From: Ben Daines [REDACTED]
Sent: Friday, June 26, 2020 2:26 PM
To: Maria Tomalova <Maria.Tomalova@arun.gov.uk>
Cc: Daniel Vick <Daniel.Vick@arun.gov.uk>; Chris Barker <[REDACTED]>
Subject: RE: Stakers Farm

Please find amended plans addressing the concerns raised in our numerous correspondence. The key amendments are as follows:

Drawing Title
Existing and Proposed Elevations - Barn 1

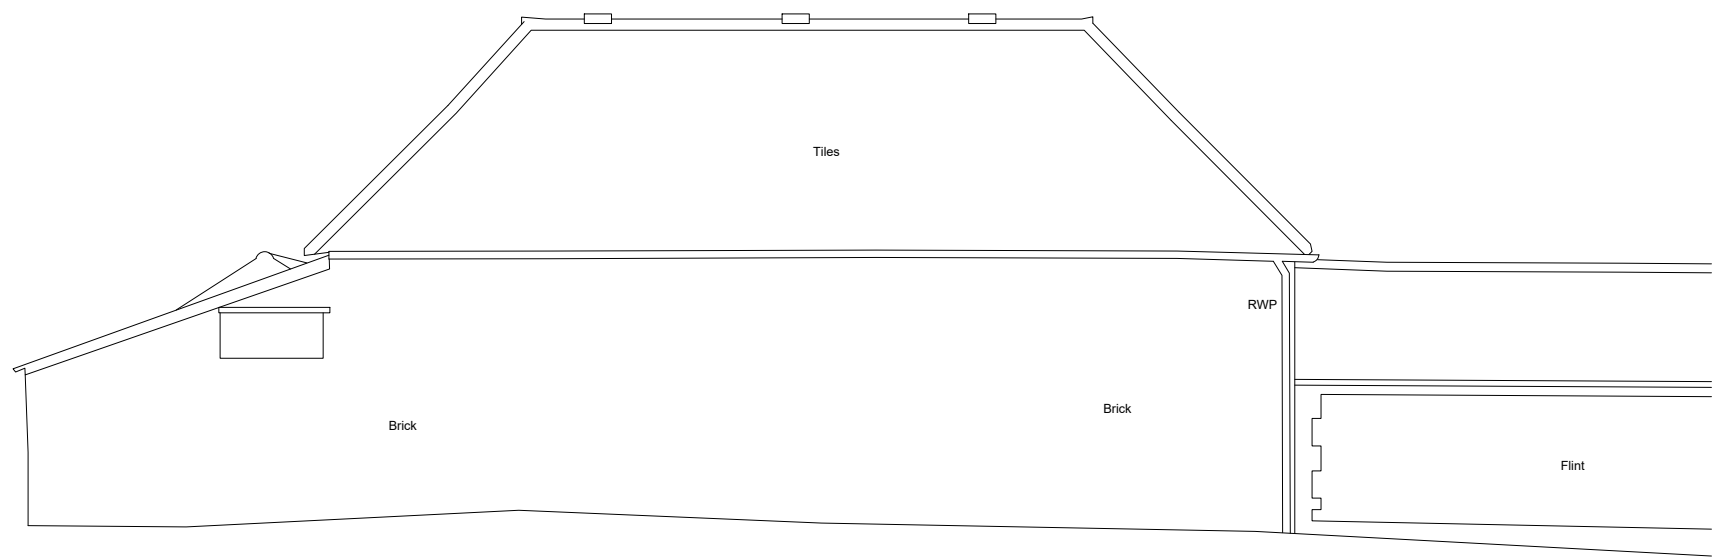
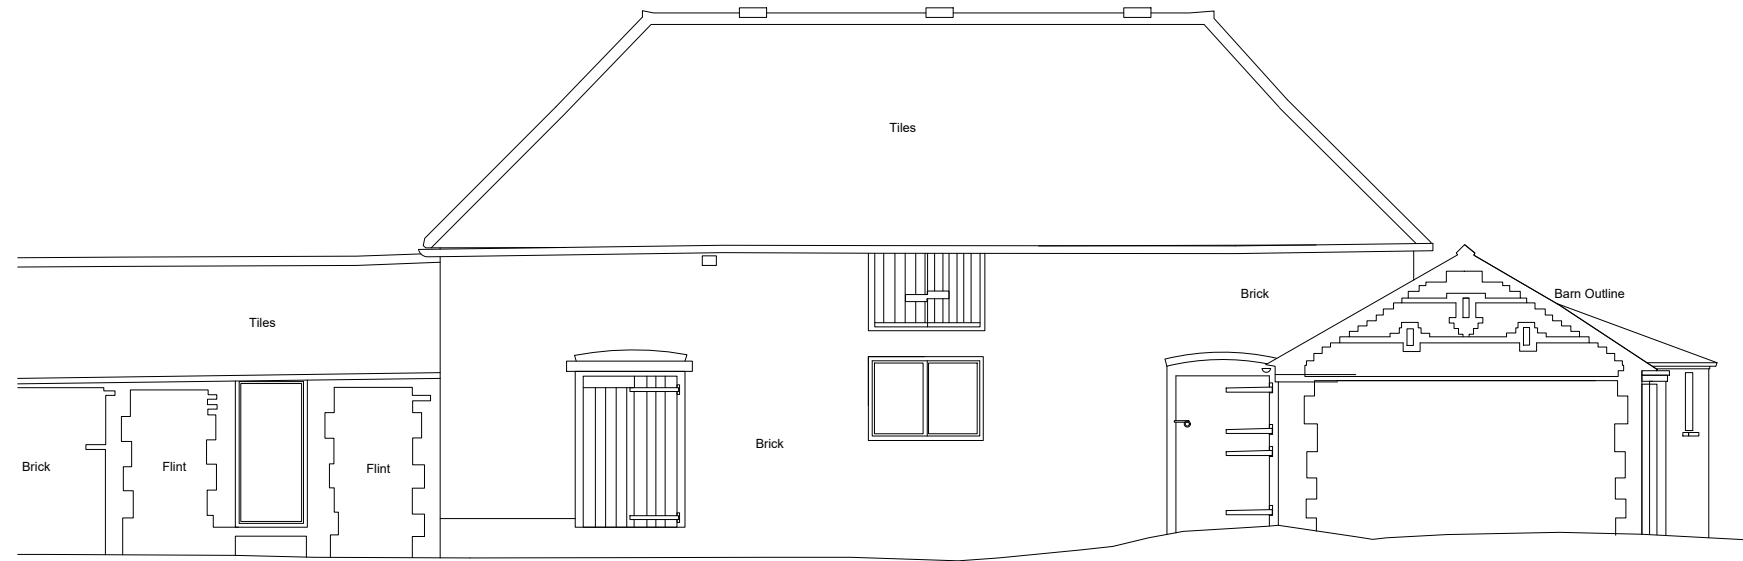
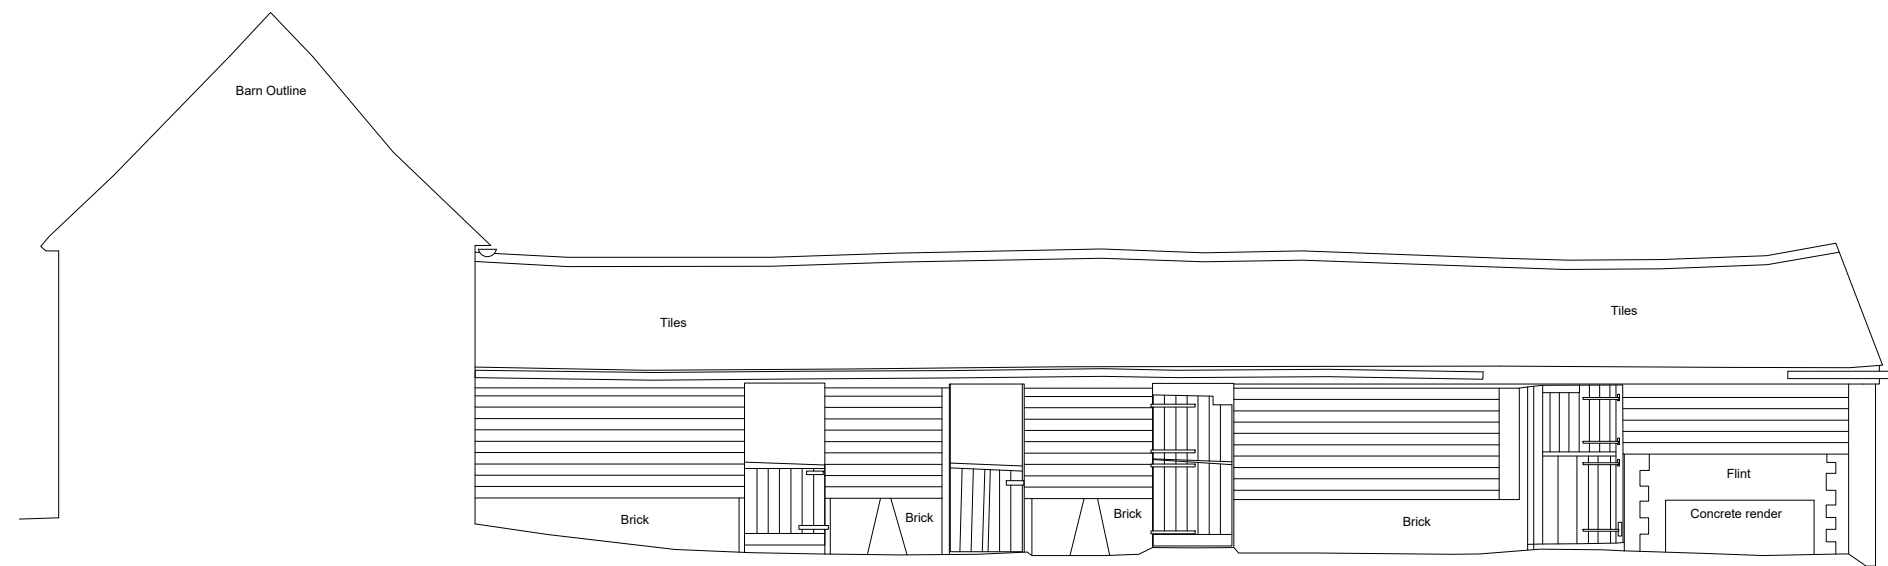
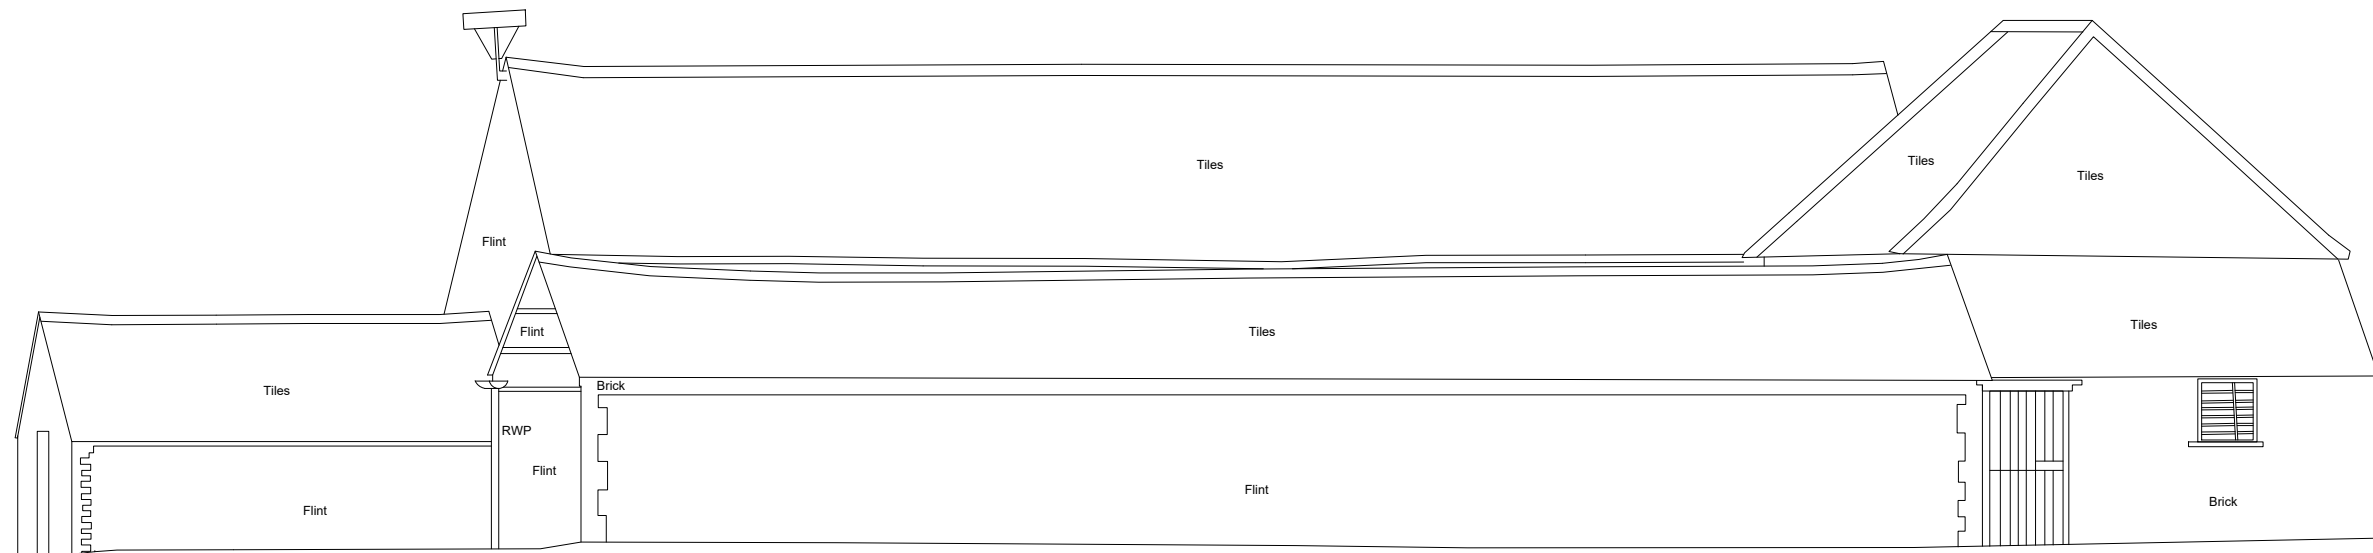
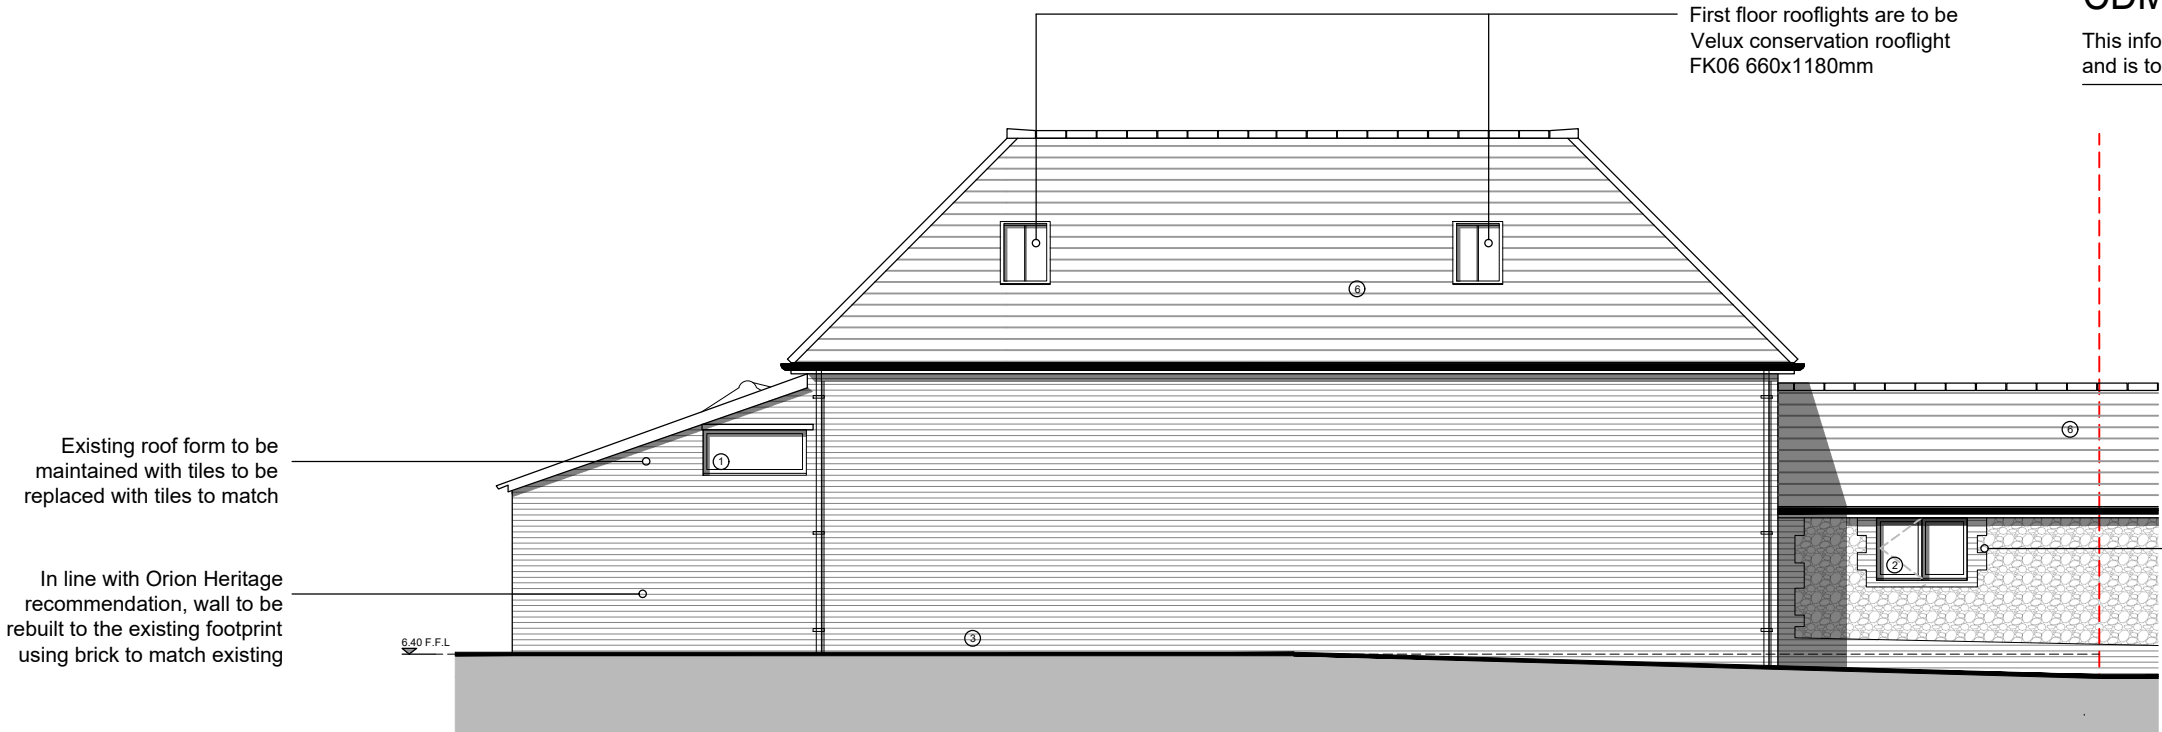
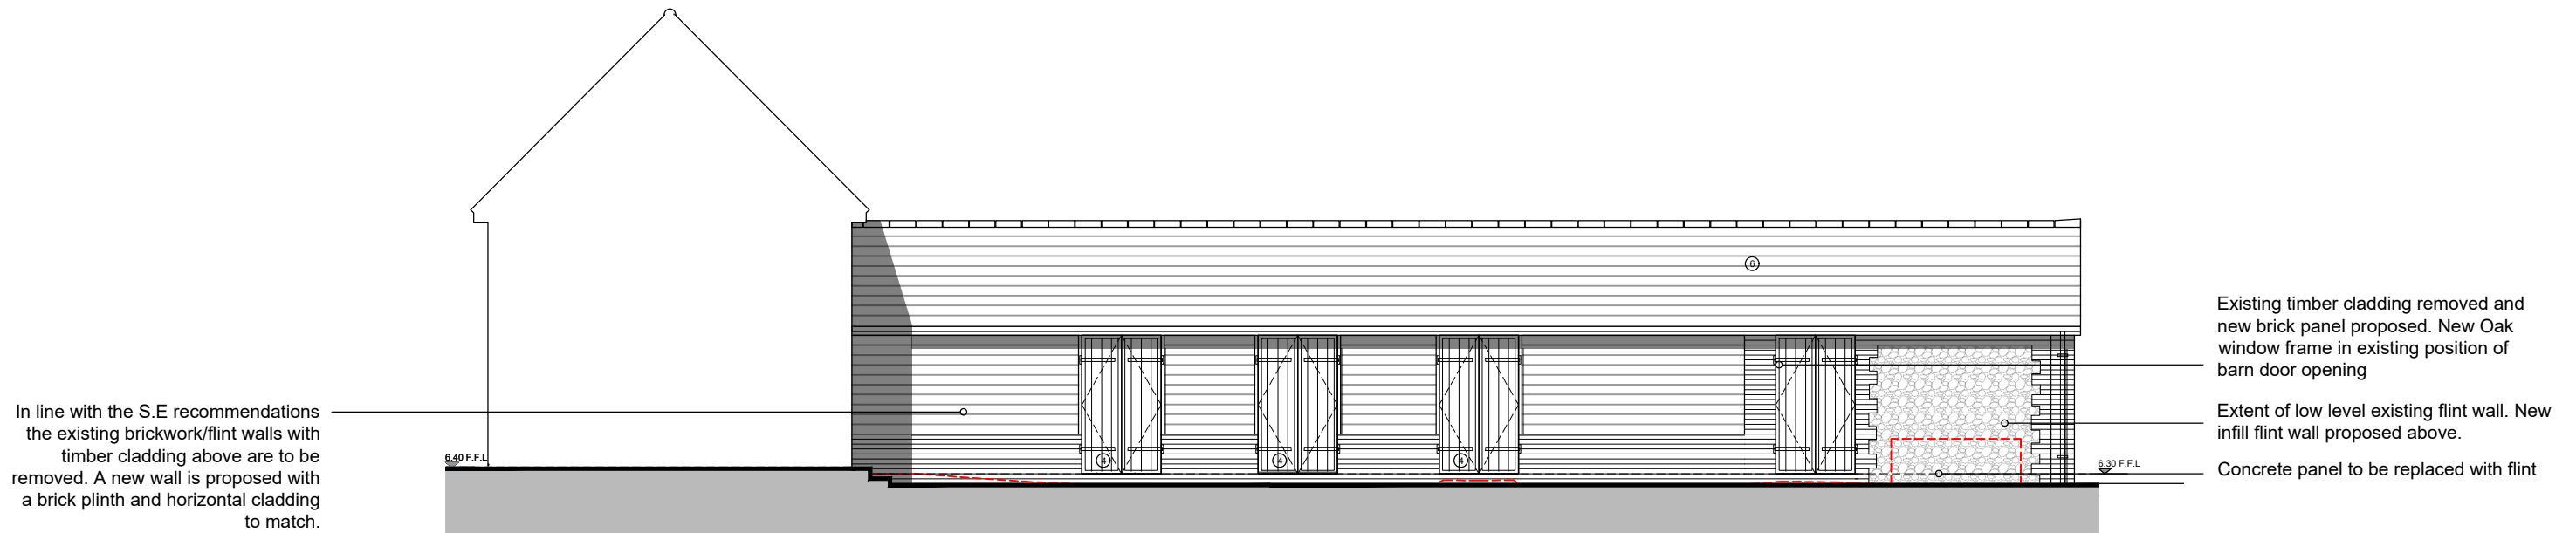
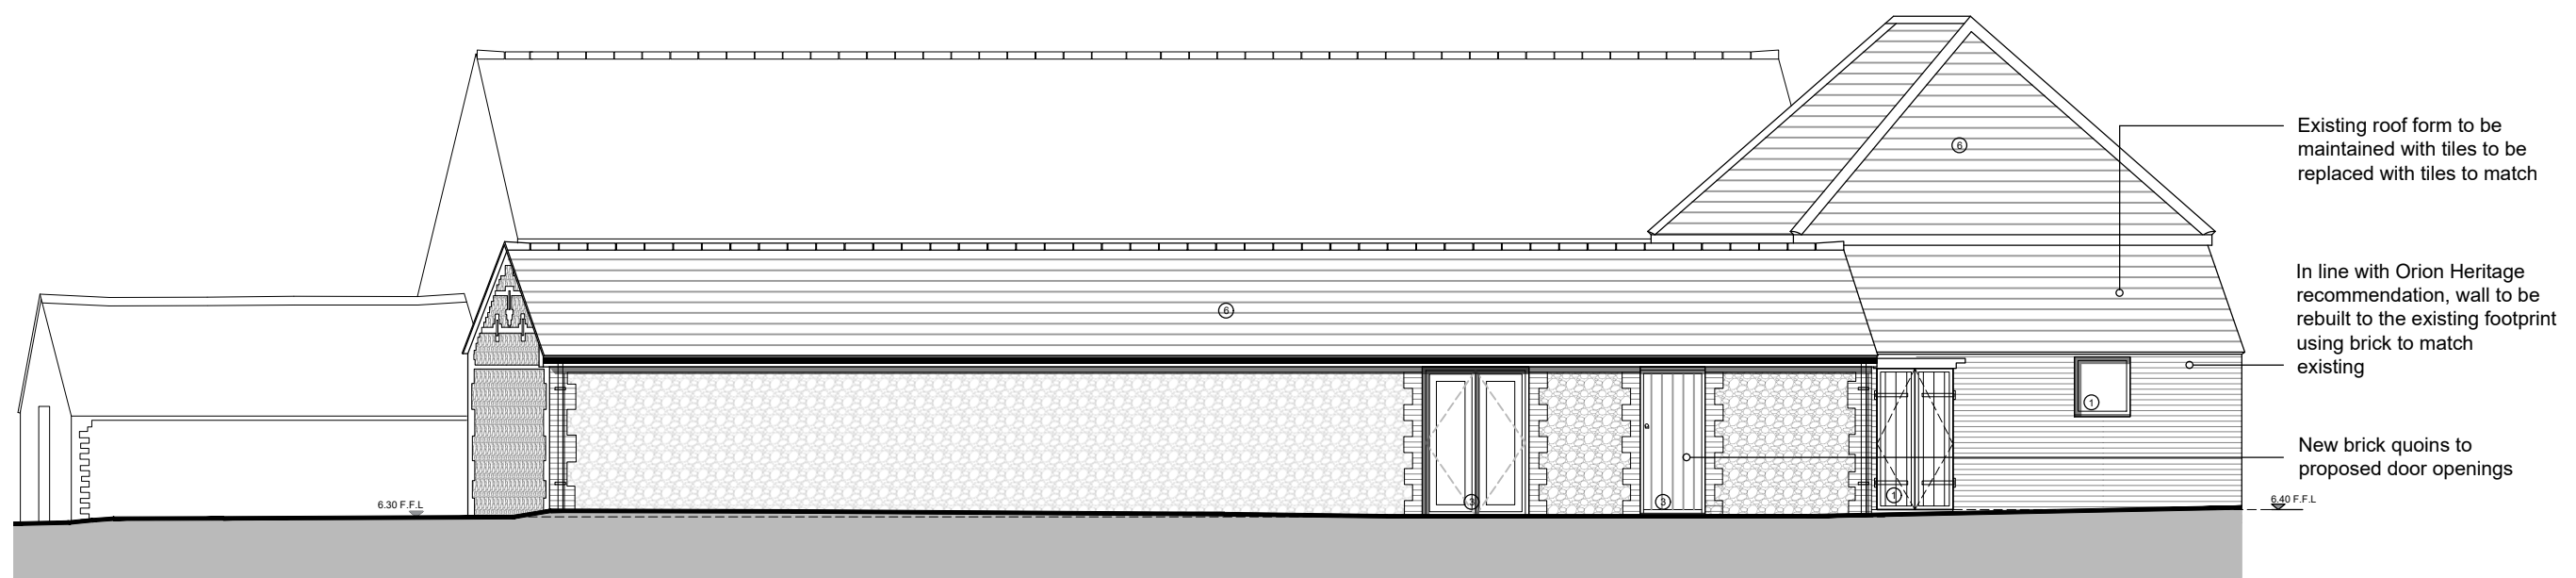
- Amount of conservation rooflights reduced to just two (one per bedroom) located on less prominent north western elevation.
- South elevation amended so size and position of new windows and doors reflect existing.
